Response to Wynne -Williams Review of the submitted Tydd Solar Farm LVA

- 1.1 This document has been prepared as a response to the review undertaken by Louise Dolan, of Wynne- Williams Associates in March 2025 ('the review') on behalf of Fenland District Council, of the submitted Tydd Solar Farm Landscape and Visual Appraisal (LVA).
- 1.2 It is noted that the review in paragraph 2.1 acknowledges that the methodology used within the submitted LVA 'is broadly in accordance with the relevant guidance given in GLIVA3 and, under paragraph 2.4, the *'criteria for reaching judgements are generally clear for both landscape and visual effects'*.

UKZ157_10 Mitigation and Enhancements Plan Key

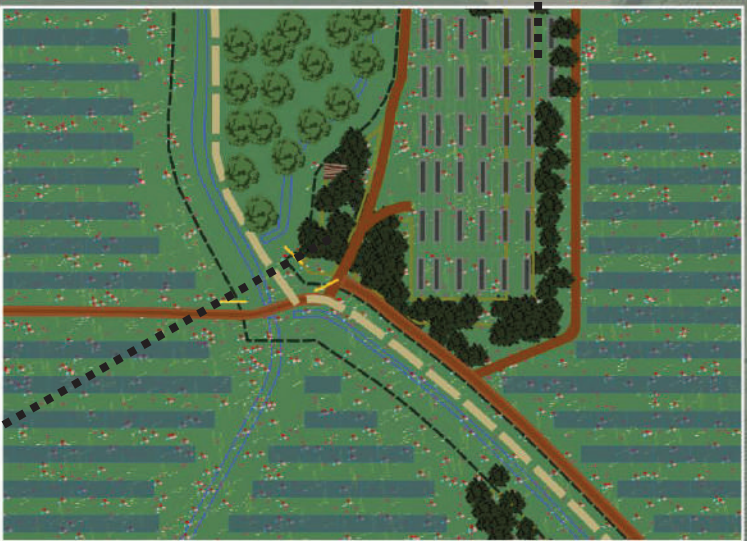
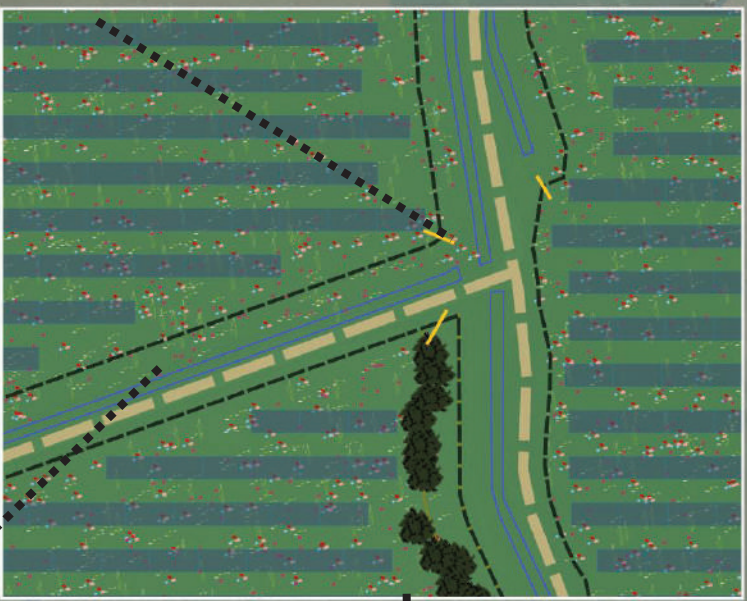
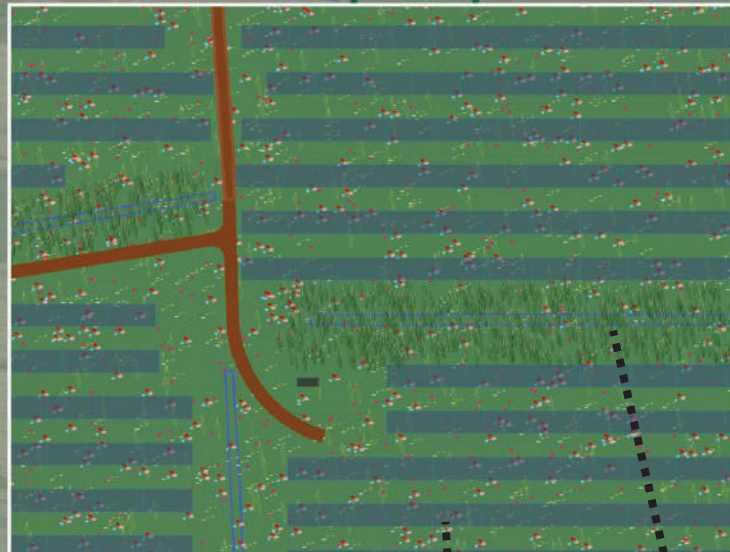
- 3.14 The review in paragraph 3.27 advocates increasing the level of new hedgerow planting, specifically to the south and west [boundaries?] of the site. The review also alludes to increasing the level of tree/hedgerow planting internally to the site along the public right of way/access track. Were this approach supported by Fenland District Council, a suitably worded condition could be applied to any planning consent.

- 3.13 The level of mitigation, in the form of new tree and hedgerow planting, currently proposed and identified in the submitted LVA is the result of considered assessment, deliberation, and design as advocate in GLVIA3. Continuous and extensive lengths of hedgerow and large woodland blocks are not a conspicuous feature of the host landscape containing the site. The present mitigation measures propose new tree and hedgerow planting at key points internally and along the boundary of the site. The present proposed mitigation is considered to reflect and be sympathetic to the existing pattern of the site and wider local landscape.
